**Department of Energy  
Bonneville Power Administration  
2520 US Highway 2 East  
Kalispell, MT 59901**

December 11, 2025

RE: Short plat application: SP-25-000012 Clear View

The Bonneville Power Administration (BPA) has reviewed the above-mentioned proposed plat and its relationship to the BPA 14-foot-wide access road. BPA does have some concerns with the activity that may occur within the short plat (Plat - Project Number SP-25-000012) and the proposed lots (numbered C and D) intended for residential use.

CLEAR VIEW SHORT PLAT

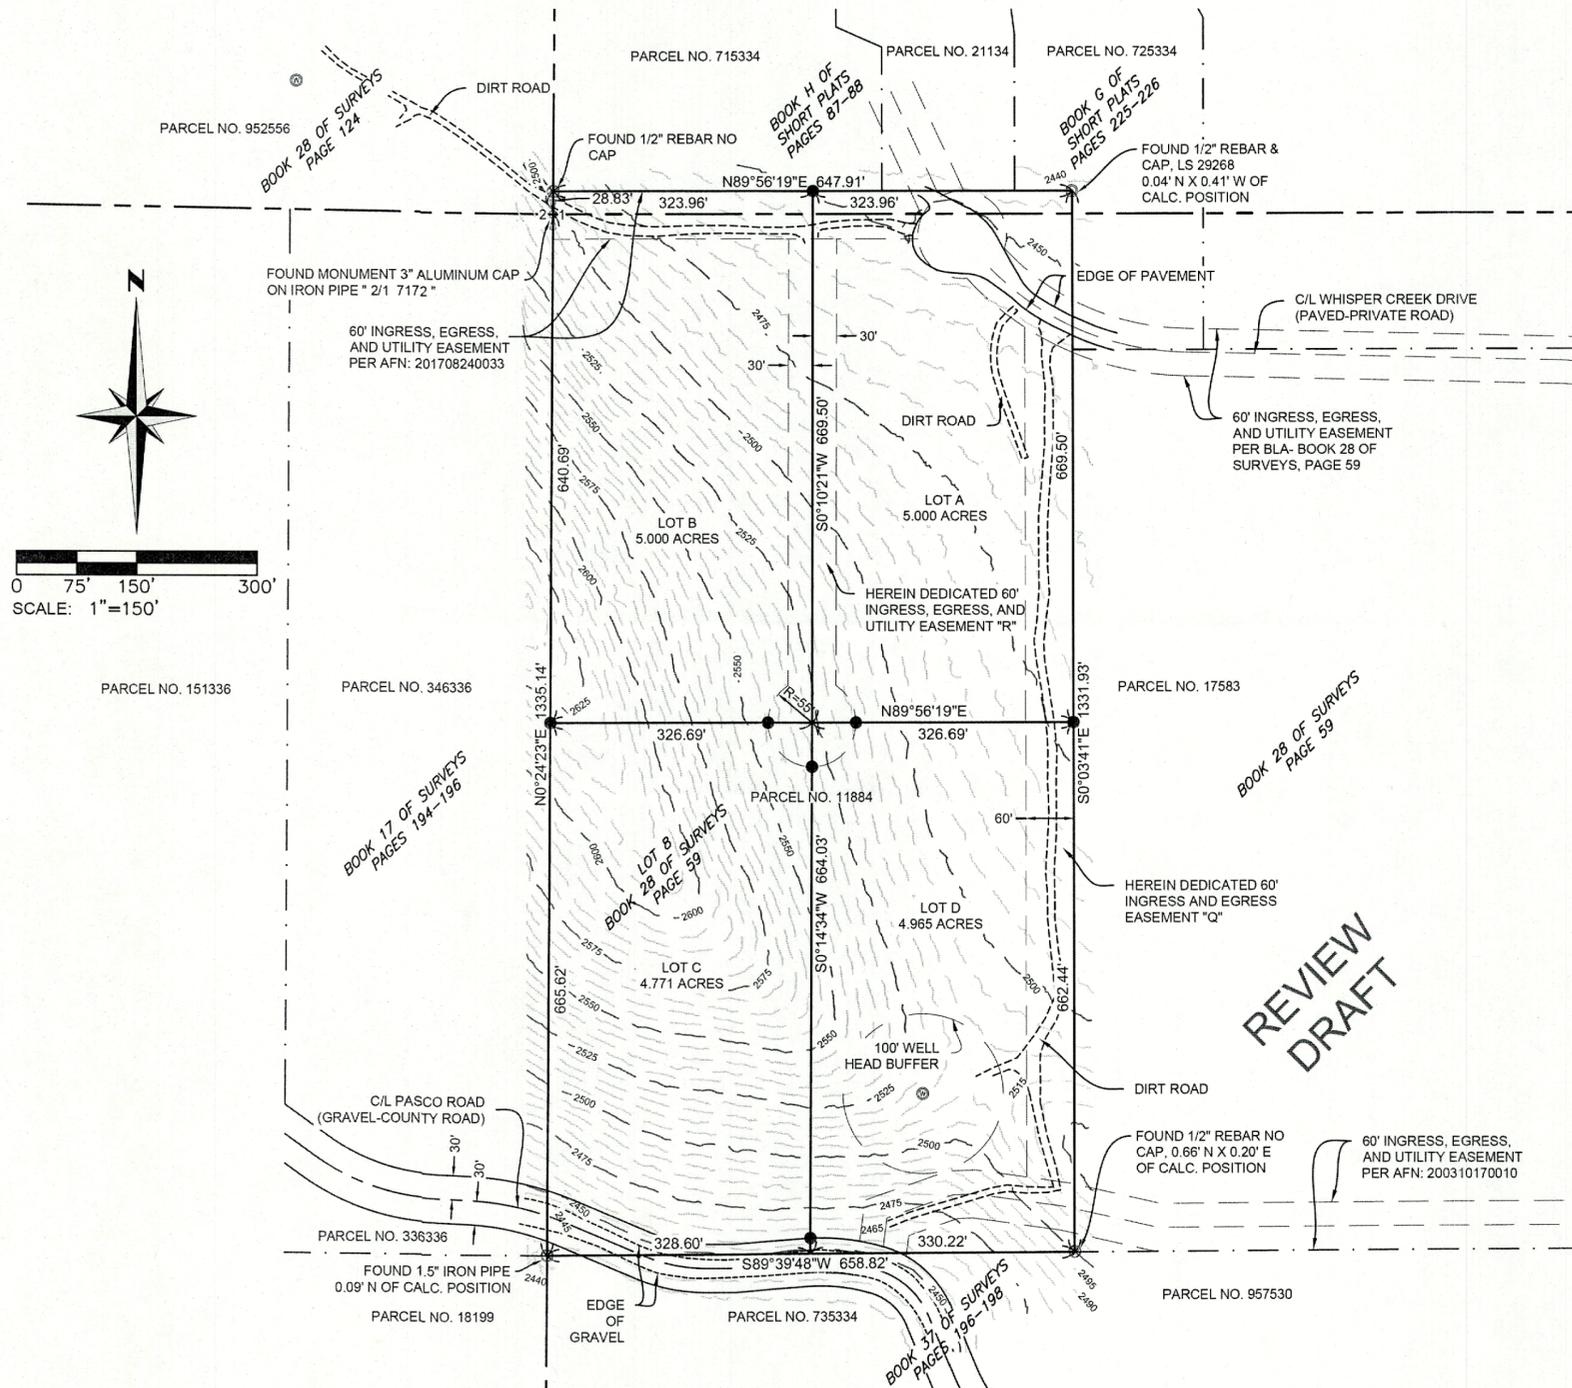
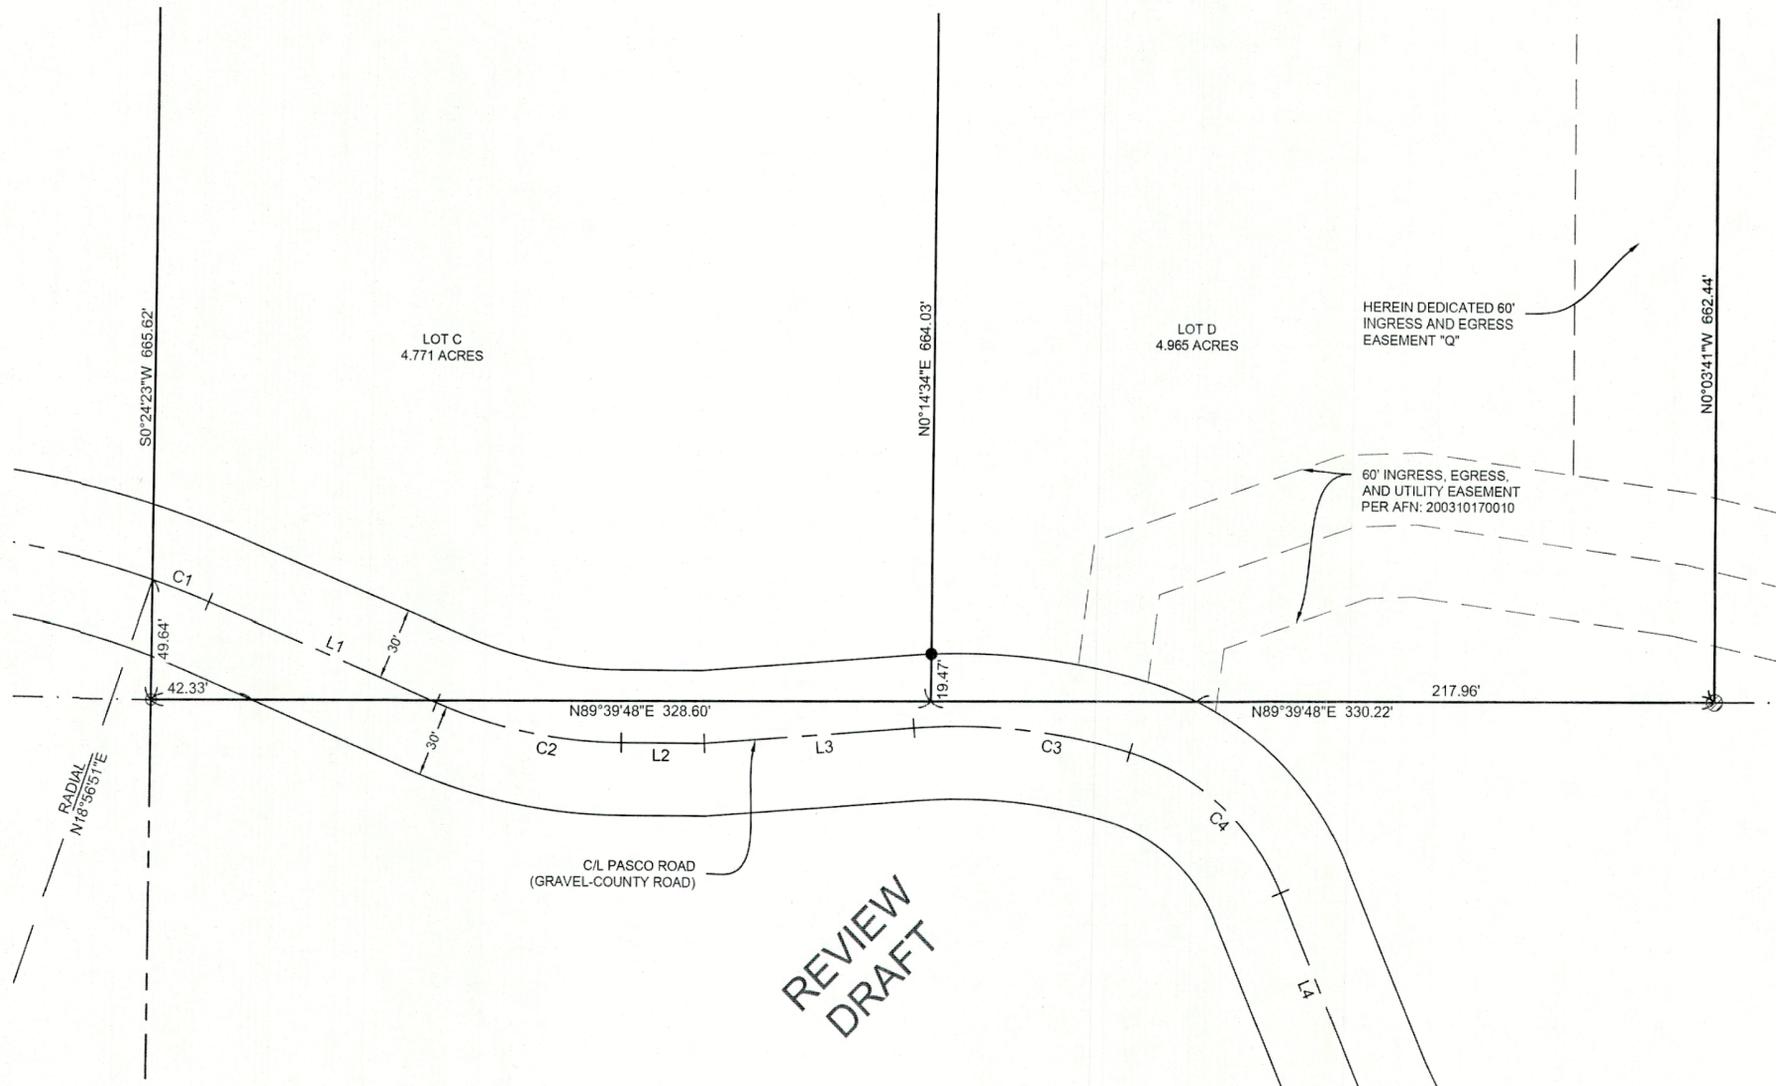
In order to avoid problems in this location and to notify prospective landowners, BPA requests that the language be included on the plat map:

*The Bonneville Power Administration (BPA) imposes certain conditions on the portions of those properties encumbered by its high voltage transmission line right-of-way and access roads. BPA does not allow structures to be built within the right-of-way, nor does it allow access to be blocked to any transmission facilities. Any activity that is to occur within the right-of-way needs to be permitted by BPA prior to installation or construction. Information regarding the permitting process for proposed uses of the right-of-way may be addressed to BPA Real Estate Field Services at (800) 282-3713.*
